Chapter V - Section 55 Subdivision Summary Form

Copper Chase at Sterling Ranch

V_1 Sub Sum review.pdf Markup Summary 6-28-2023

FINAL PLAT  
COPPER CHASE AT STERLING RANCH  
FILING NO. 1  
JOB NO. 09-014  
DATE PREPARED: 04/27/2023  
DATE REVISED: 07/14/2023

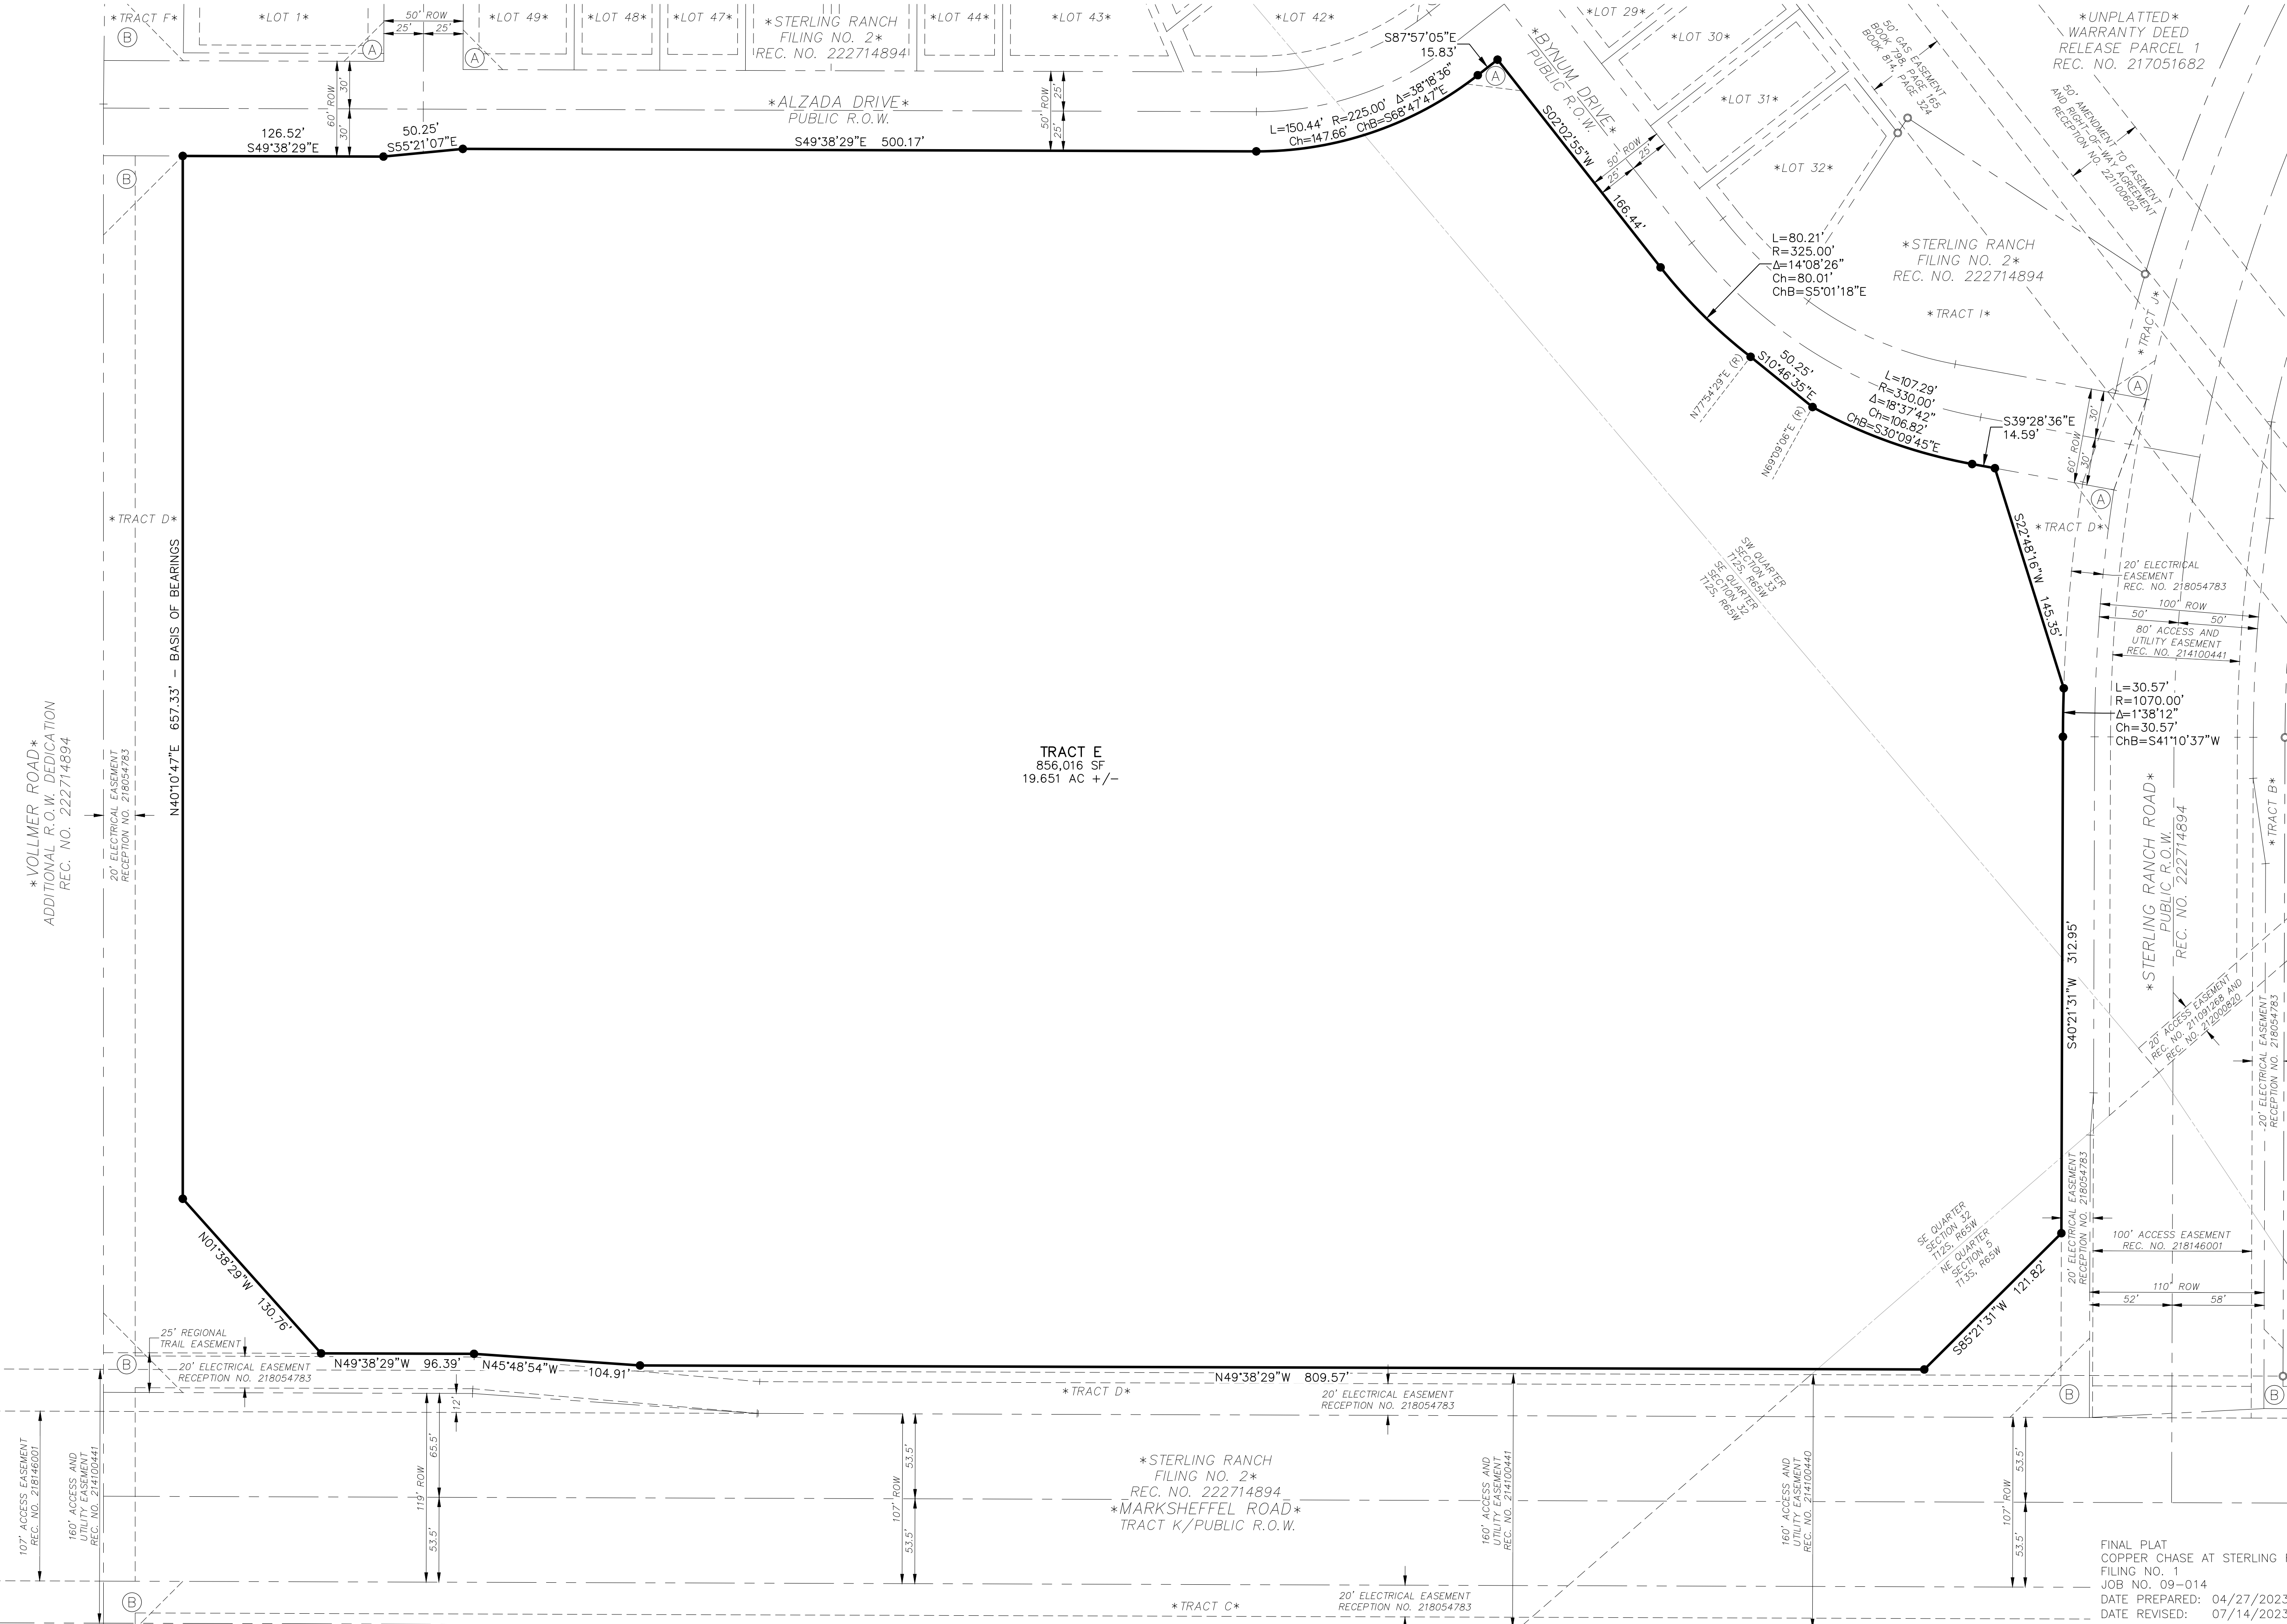
Areas and % do not match with what is shown on plat cover sheet. Please revise so both documents match.

Areas and % do not match with what is shown on plat cover sheet. Please revise so both documents match.
